Addendum No. 1

RE: Contract # C204359

US-70 FROM US-70 BUS TO NEUSE RIVER BRIDGE WITH INTERCHANGES
AT SR-1501 (SWIFT CREEK RD) AND SR-1919 (WILSONS MILLS RD).

The following revisions have been made to the Structure plans.

PROJECT REFERENCE NO.		SHEET NO.	
W-5600		2A-4	
ROADWAY DESIGN ENGINEER	PAVEMENT DESIGN ENGINEER		
8/9/2021	8/9/2021

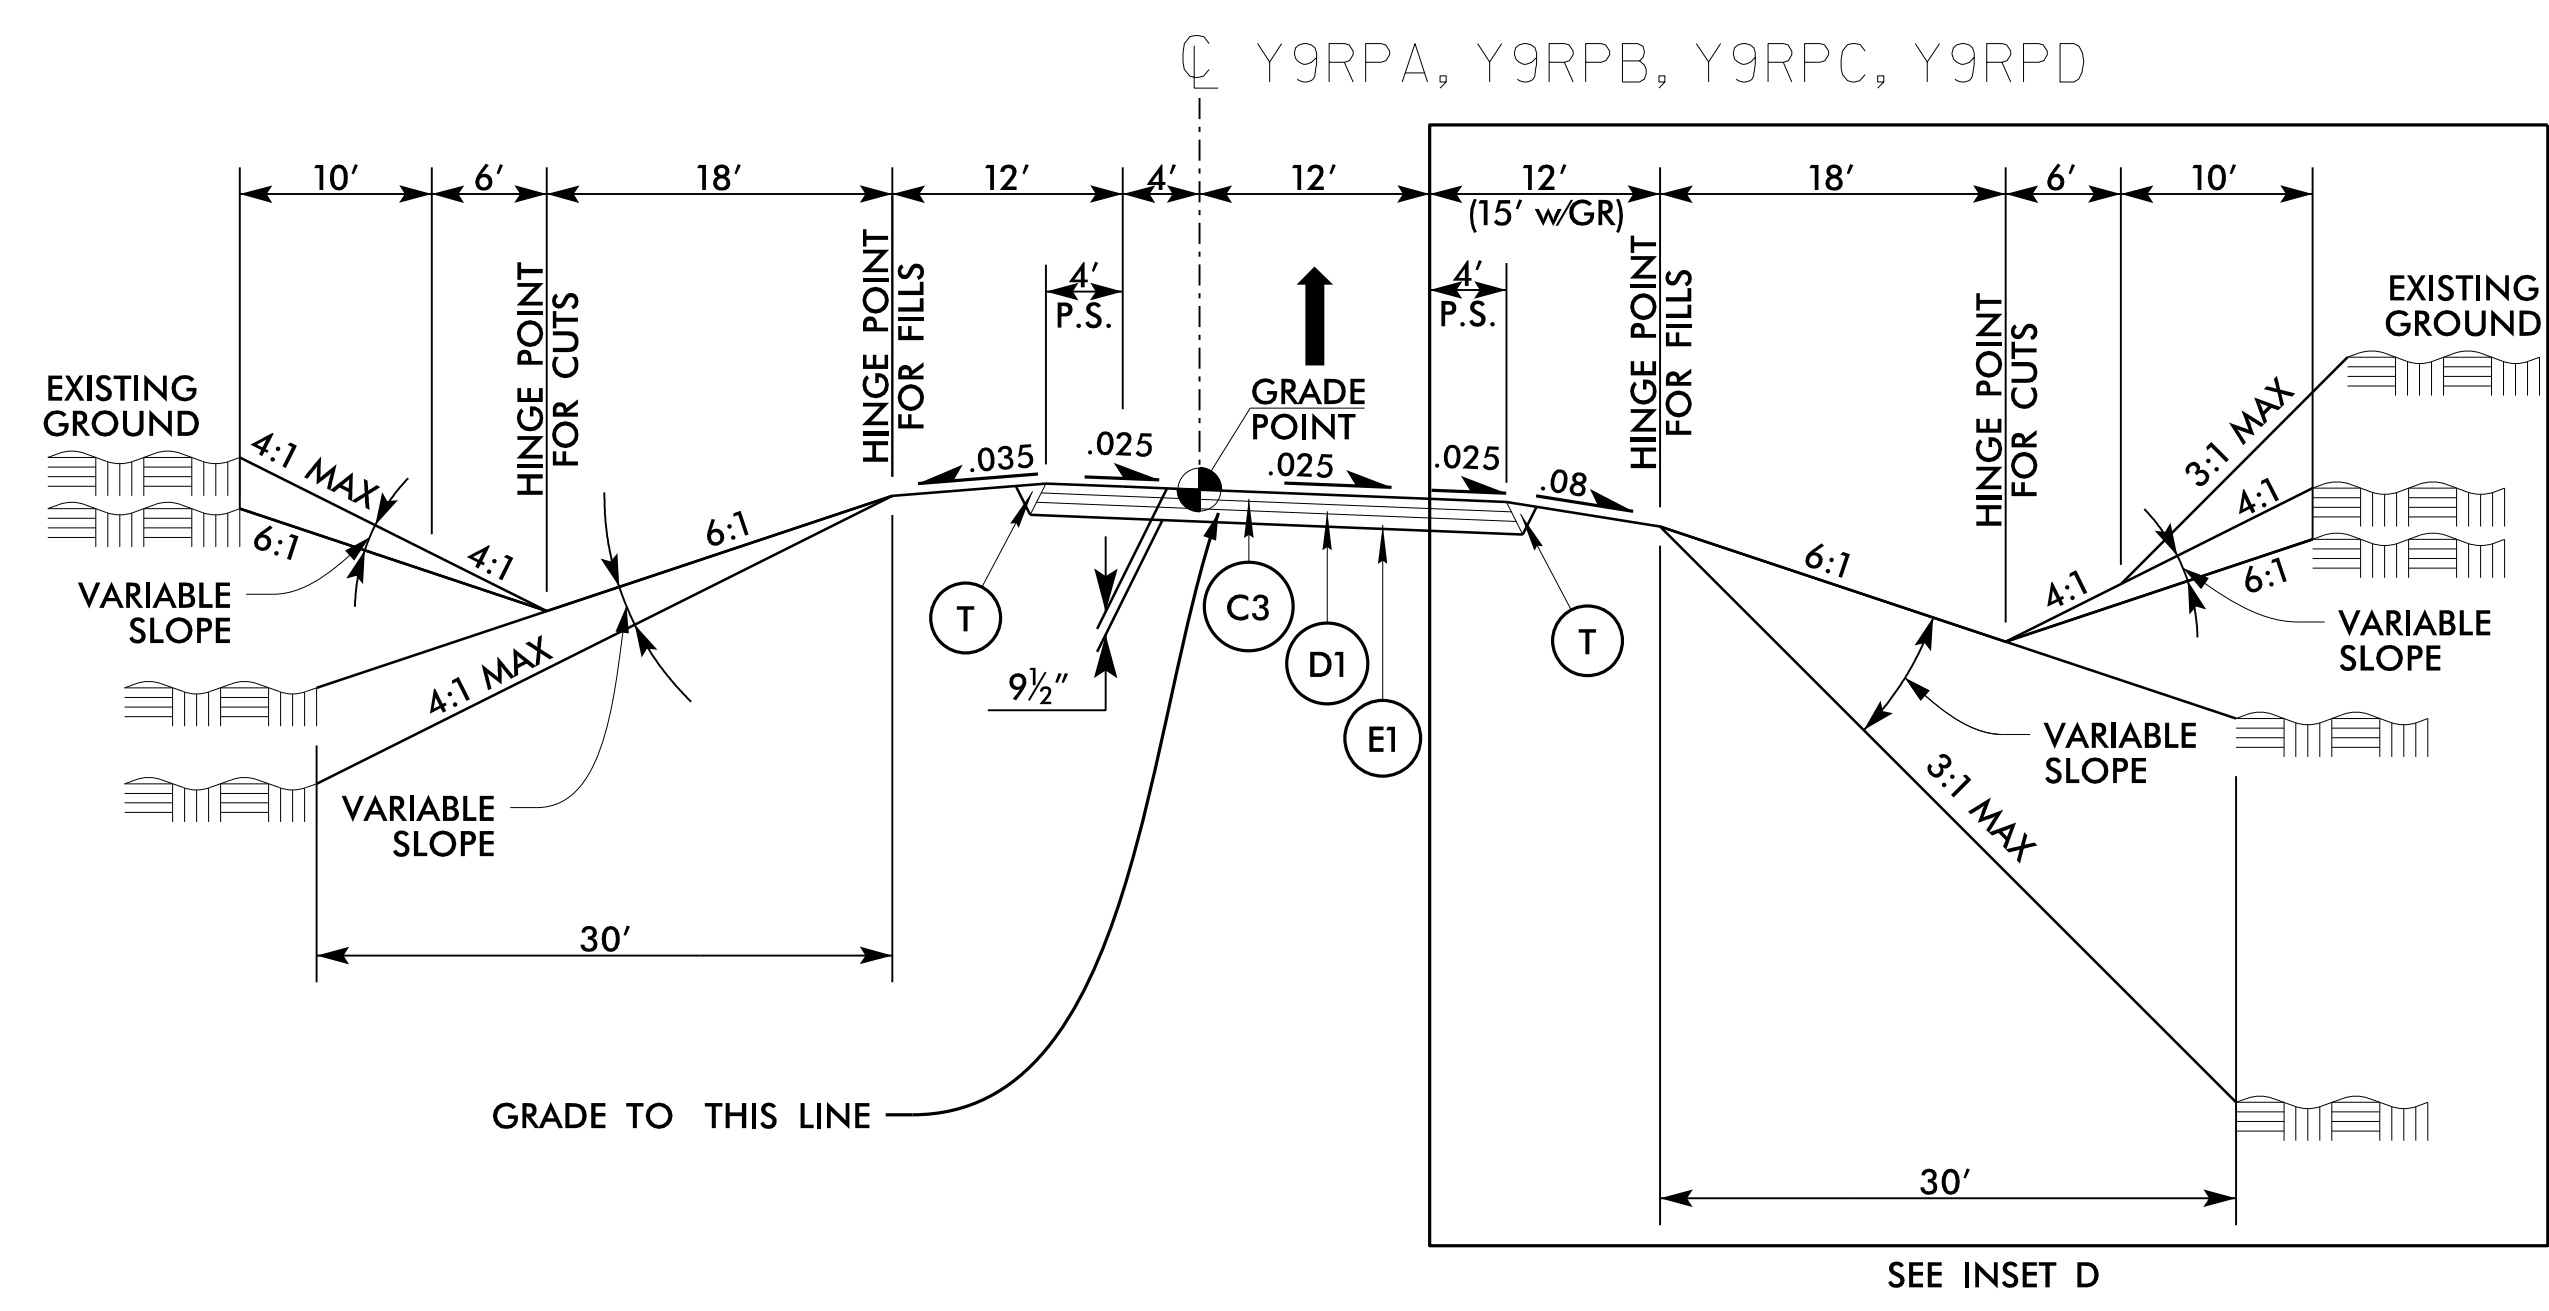
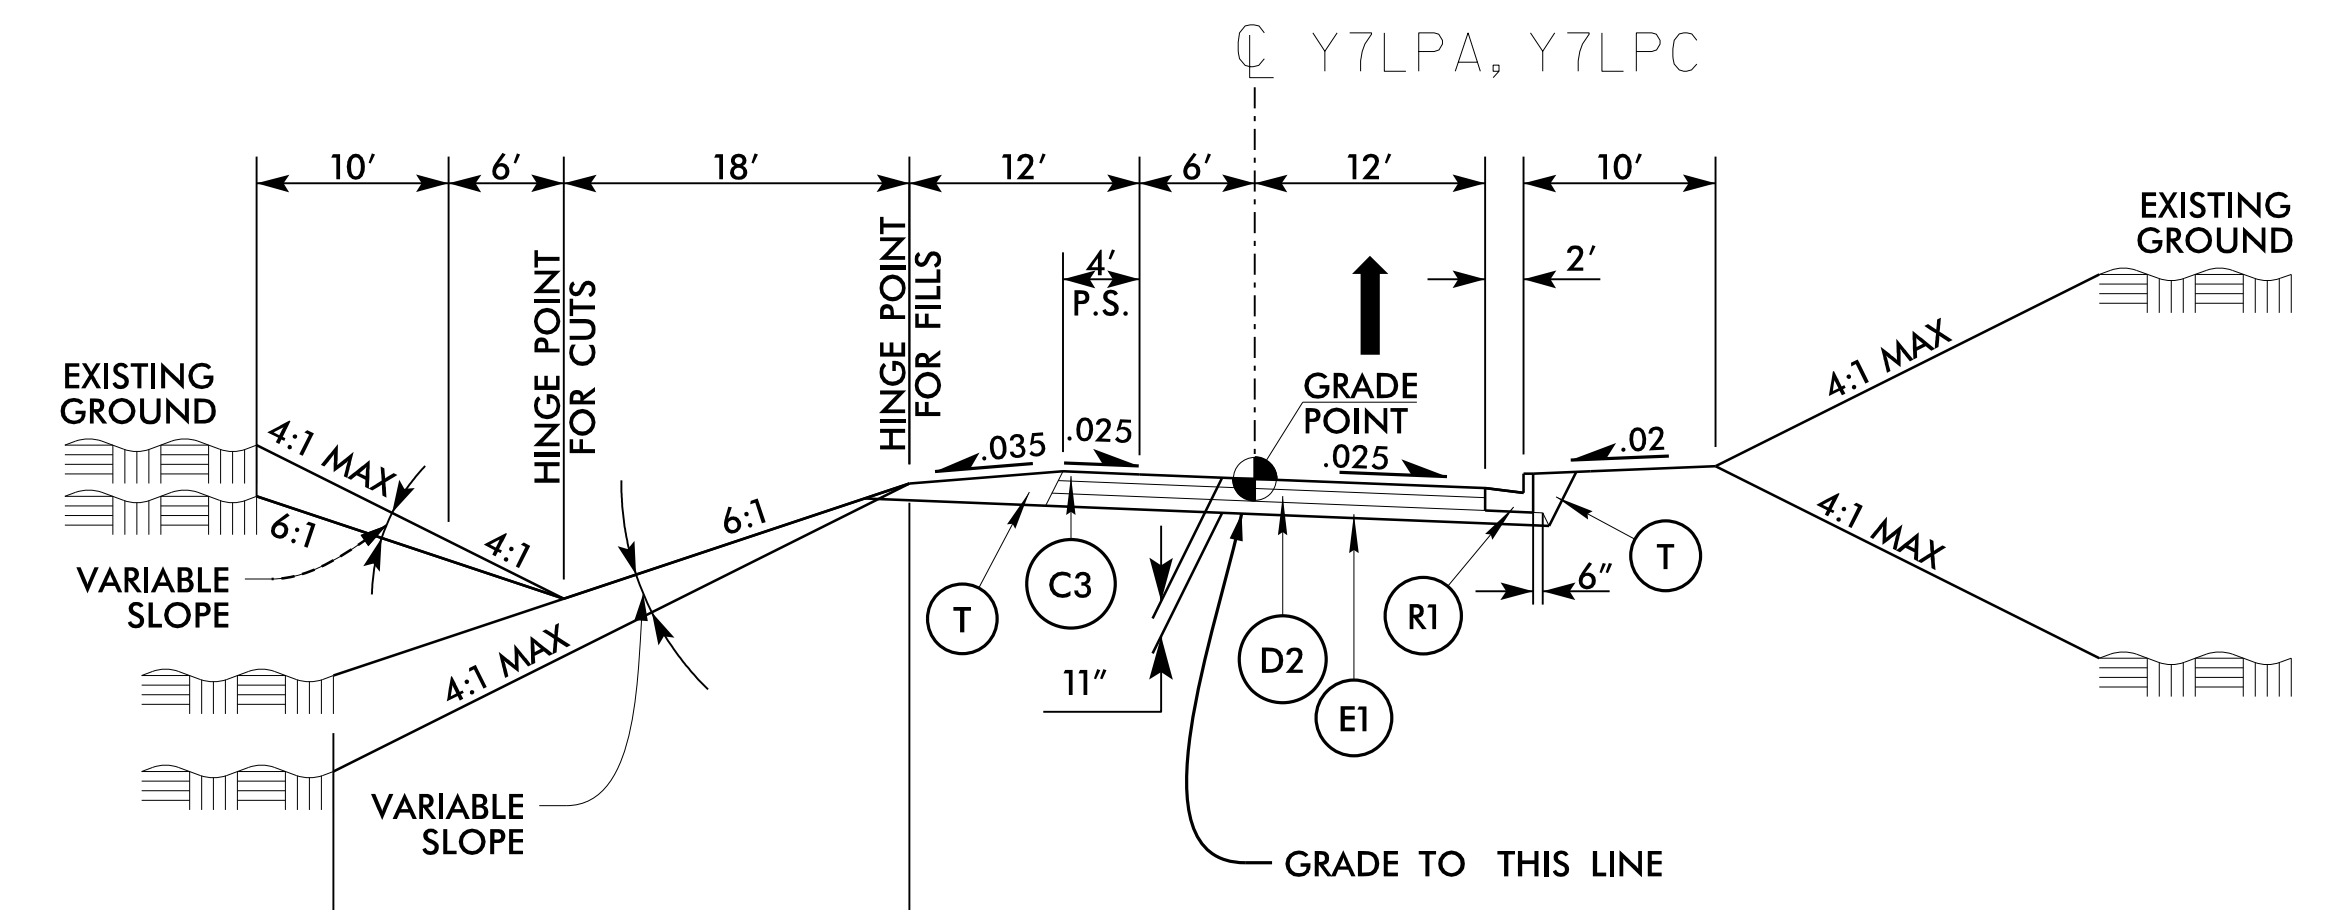
Sheet No.	Revision
2A-1	Revised to reflect quantity and pay item changes below
2A-2	Revised to reflect quantity and pay item changes below
2A-3	Revised to reflect quantity and pay item changes below
2A-4	Revised to reflect quantity and pay item changes below
2A-5	Revised to reflect quantity and pay item changes below

<u>Item</u>	<u>Description</u>	<u>Old Quantity</u>	<u>New Quantity</u>
0080-1297000000-E-607	MILLING ASPHALT PAVEMENT, 2-1/2" DEPTH	125,000 SY	136,200 SY
0085-1523000000-E-610	ASPHALT CONC SURFACE COURSE, TYPE S9.5C	43,600 TON	DELETED
0086-1575000000-E-620	ASPHALT BINDER FOR PLANT MIX	19,790 TON	17,175 TON
0360-1308000000-E-607	MILLING ASPHALT PAVEMENT, 2-1/2" TO 4" DEPTH	NEW ITEM	24,800 SY
0361-1524200000-E-610	ASPHALT CONC SURFACE COURSE, TYPE S9.5D	NEW ITEM	43,600 TON
0362-1577000000-E-620	POLYMER MODIFIED ASPHALT BINDER FOR PLANT MIX	NEW ITEM	2,490 TON
0327- 8196000000-E-420	CLASS A CONCRETE (CULVERT)	939.7 CY	858.7 CY

**ROADWAY DATA**

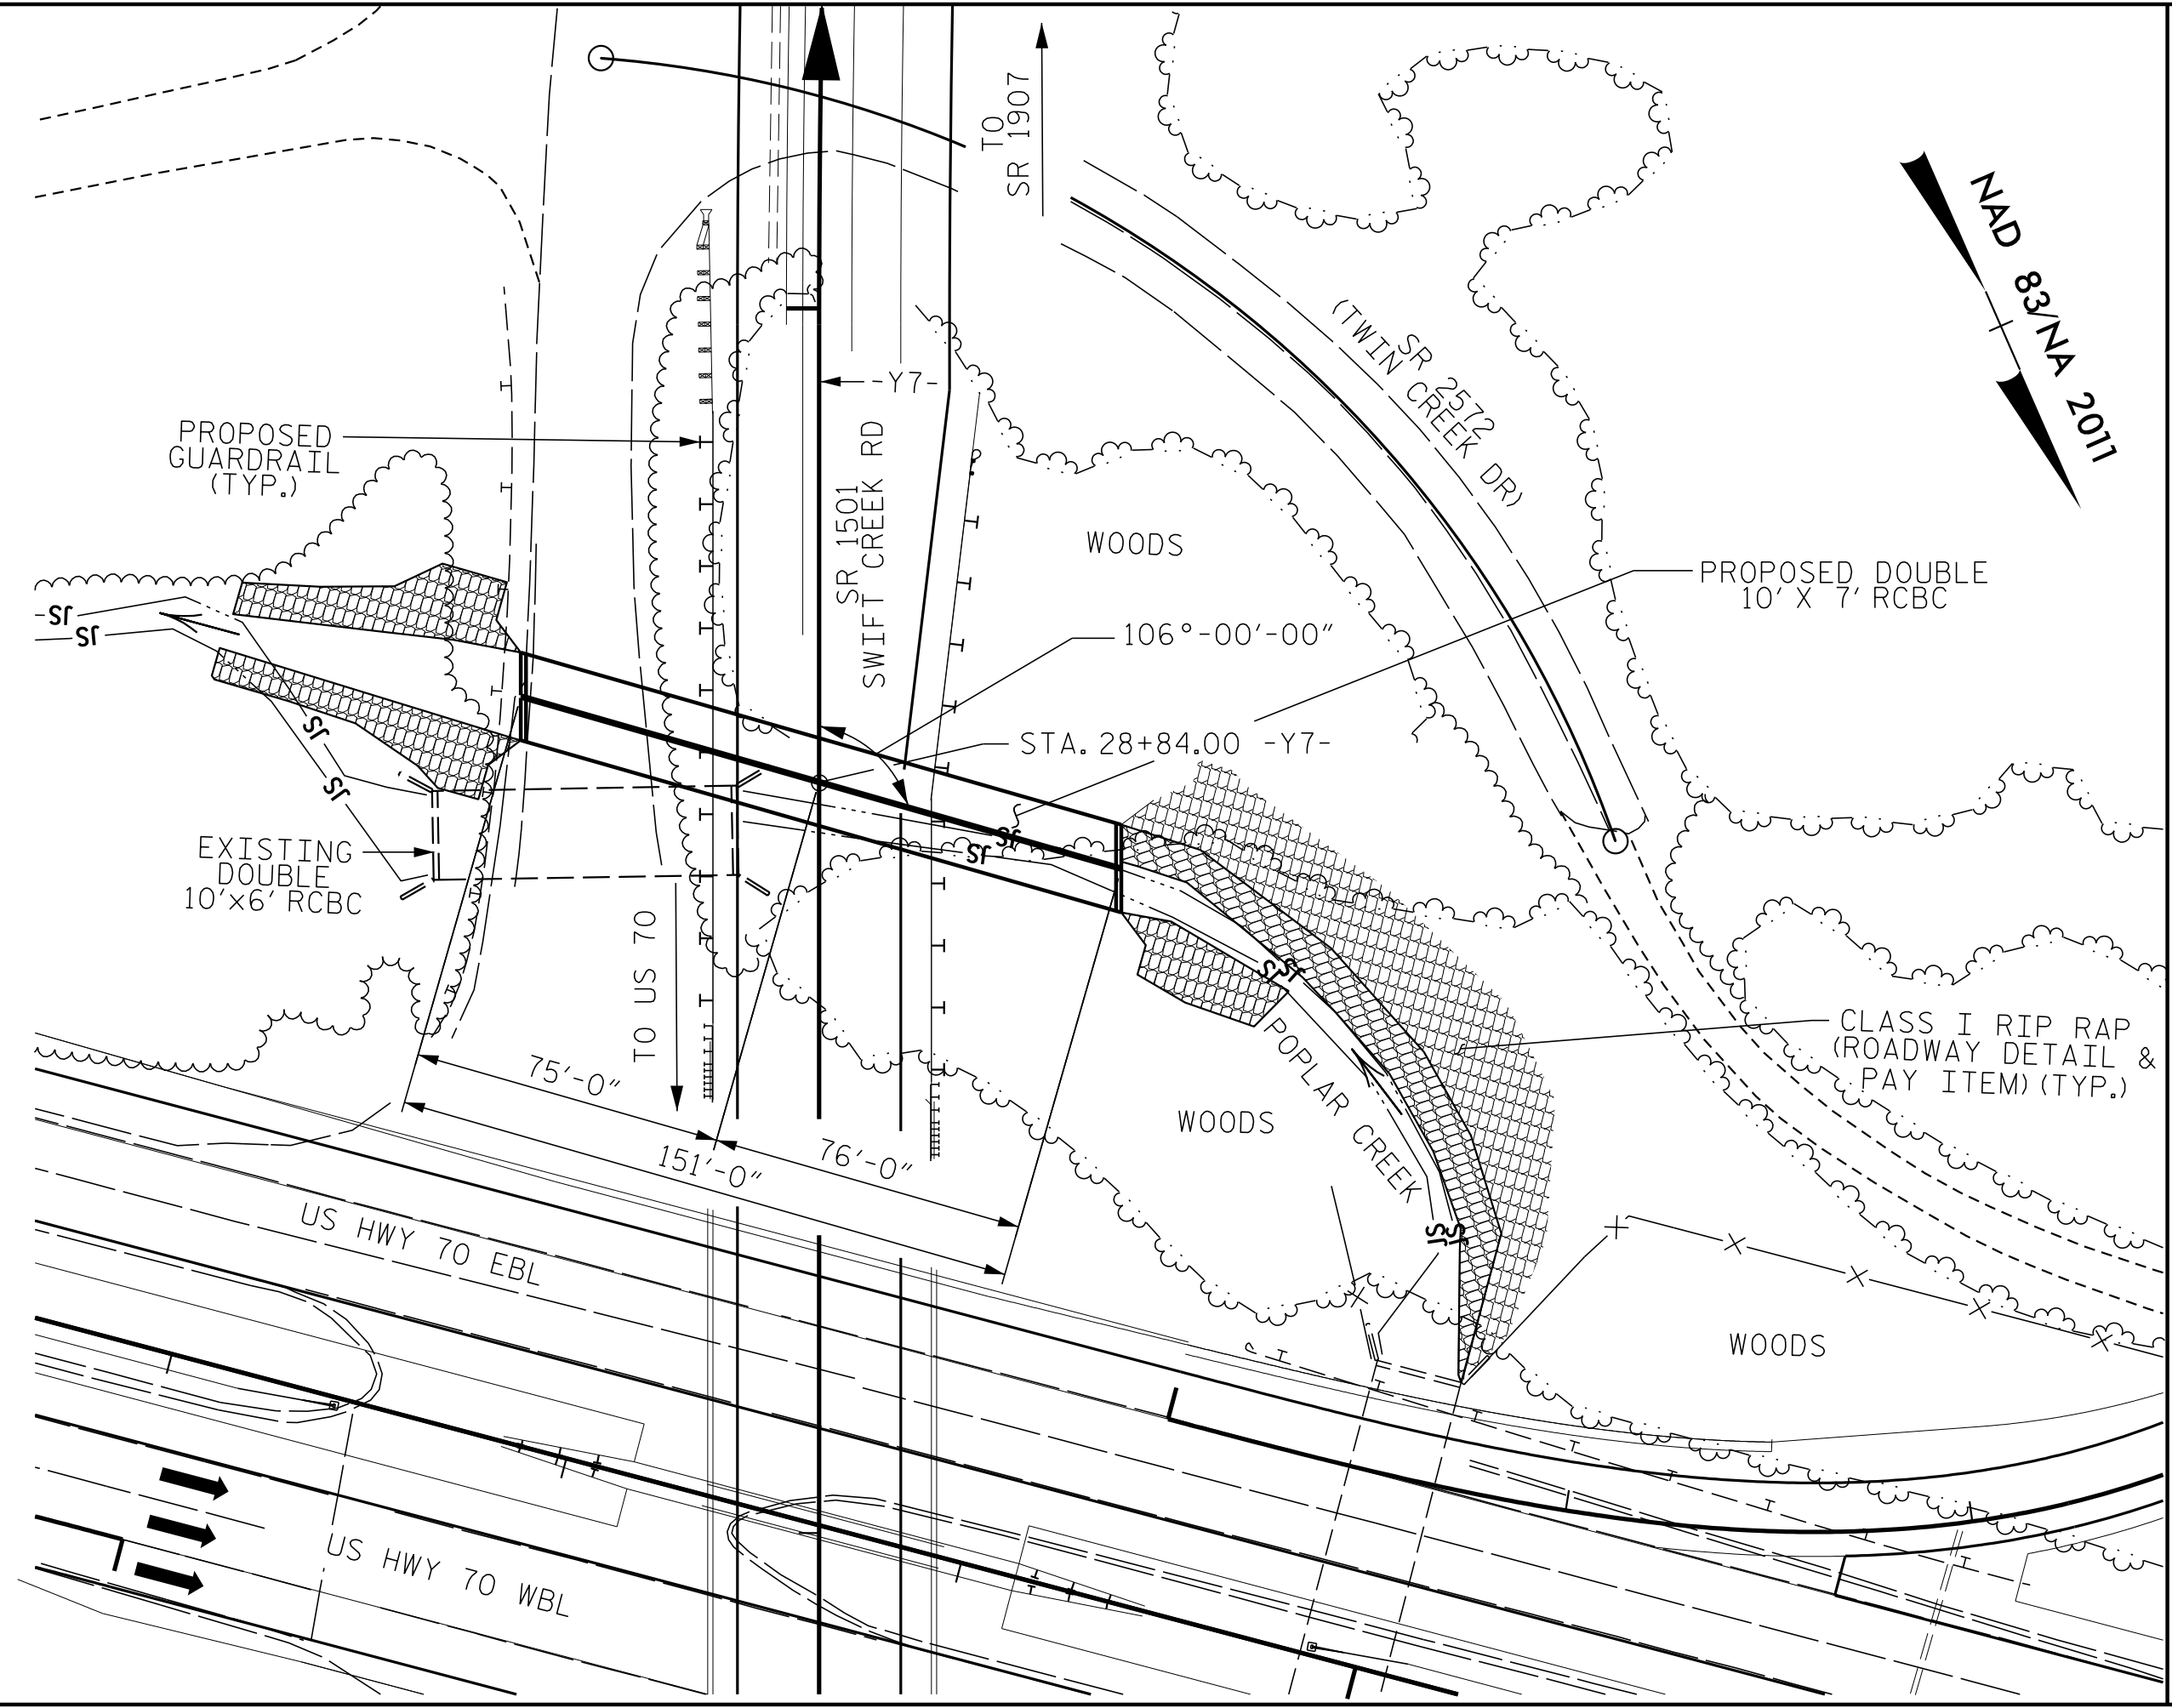
Sheet No.	Revision
C3-1	Revised to reflect quantity change below
